**Tooheys Brewery,
Lidcombe -
Cogeneration Facility**

Response to
Submissions

November 2009

**Figure 3 Proposed Co-generation Facility Process**

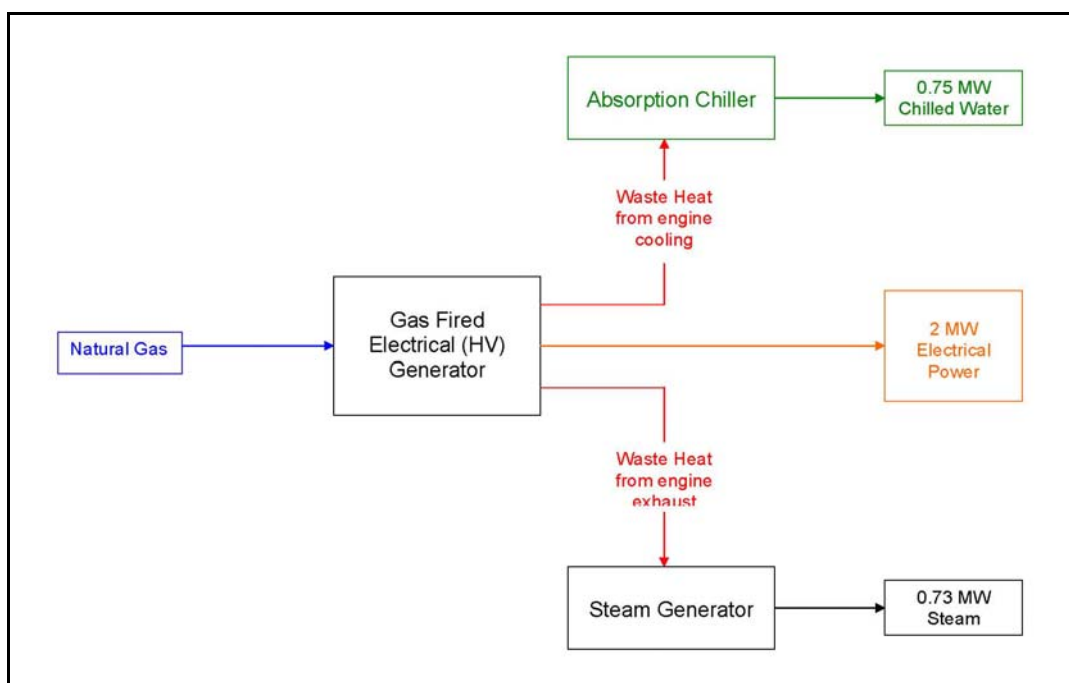
The EA does not provide sufficient description of the project, especially for the production of steam and hot water. Furthermore, it is unclear how the hot water will be generated from the engine cooling system and how it will be used to produce chilled water (Last statement of para 3, *Sec 3 Project Description* of the EA).

Heat recovery will initially be from the high temperature jacket water (1065kw) and exhaust system (720kw).

Heat from the engine jacket water will be utilised through the isolation heat exchanger and passed on to a single stage hot water absorption chiller. There will be some 1065 kW of heat available from the jacket water that can be converted into approximately 750 kW of chilled water for use within the brewery. The proposed model of the absorption chiller is a Broad BDH 75 with stainless tubes in the evaporator.

Waste heat from the engine exhaust system will be reclaimed via an exhaust gas heat exchanger for the purpose of producing steam for use within the brewery. It is anticipated that the exhaust discharge from the generator set will be utilised, via a waste heat boiler which will be a two pass fire tube construction, with a thermal capacity of approximately 720kW when producing 9 bar steam. create approximately 1MW of saturated steam at a nominal pressure of 800-900kPa. The steam produced will supplement the existing plant steam system.

Figure 5-2: Heat Radiation vs. Distance Plot for Fire inside the Engine Room

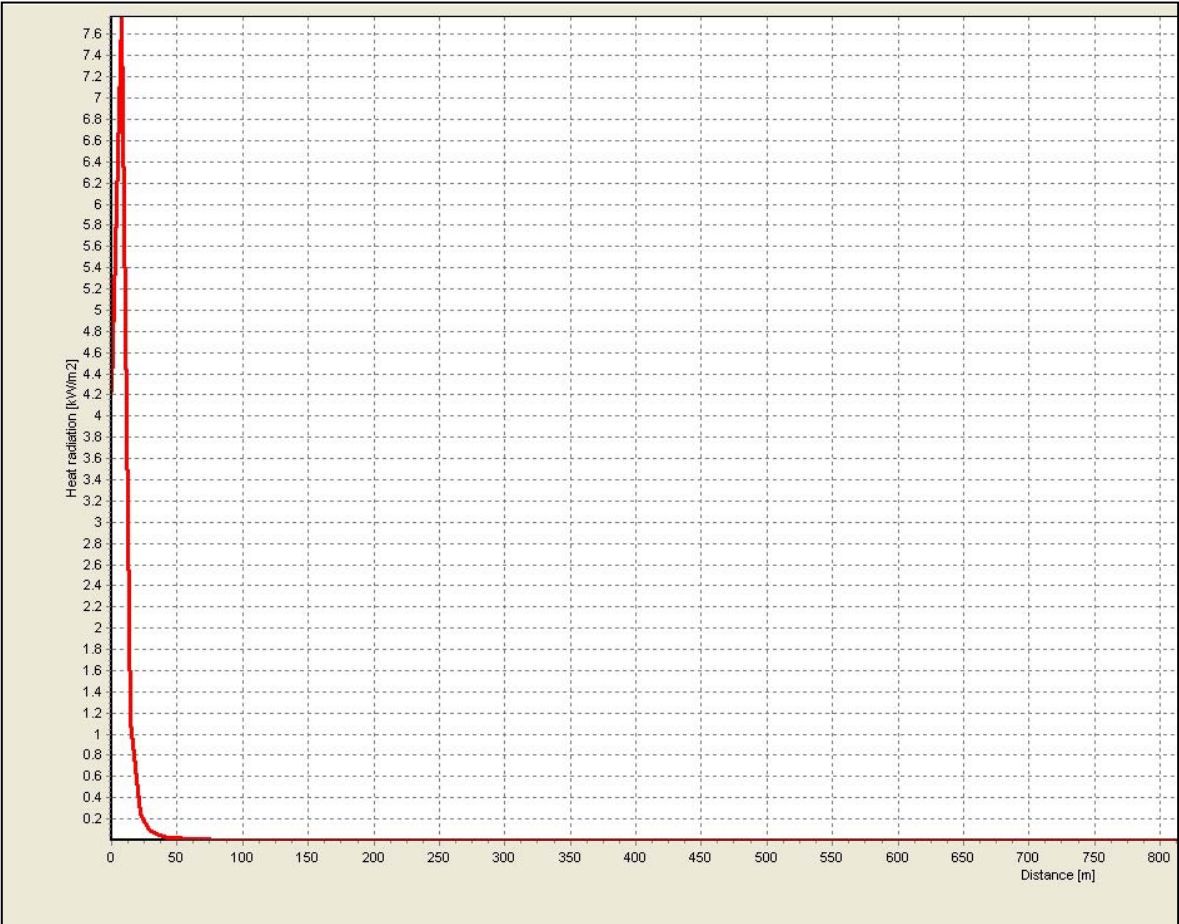
- iv. What is the length of the jet fire and is it likely to directly impinge on equipment in the engine room.
 - v. *Fig 5-2 Heat Radiation vs. Distance Plot for Fire inside the Engine Room* shows a heat radiation of 4.4 kW/m² at the edge of the fire and a maximum of 7.8 kW/m² at greater distance from the fire. This again is surprising and some explanation should be provided.

With a jet flame, the max heat flux occurs at a certain distance rather than at the point of release. This is because the gas being released needs time to completely mix with air before it gets burnt. . Since it came out as a jet, the gas would be at ambient temperature at a distance very close to the hole. Any fire close to it will be pushed away by the gas being released. In addition, it also needs time to achieve elevated temperature required for fully developed flame.
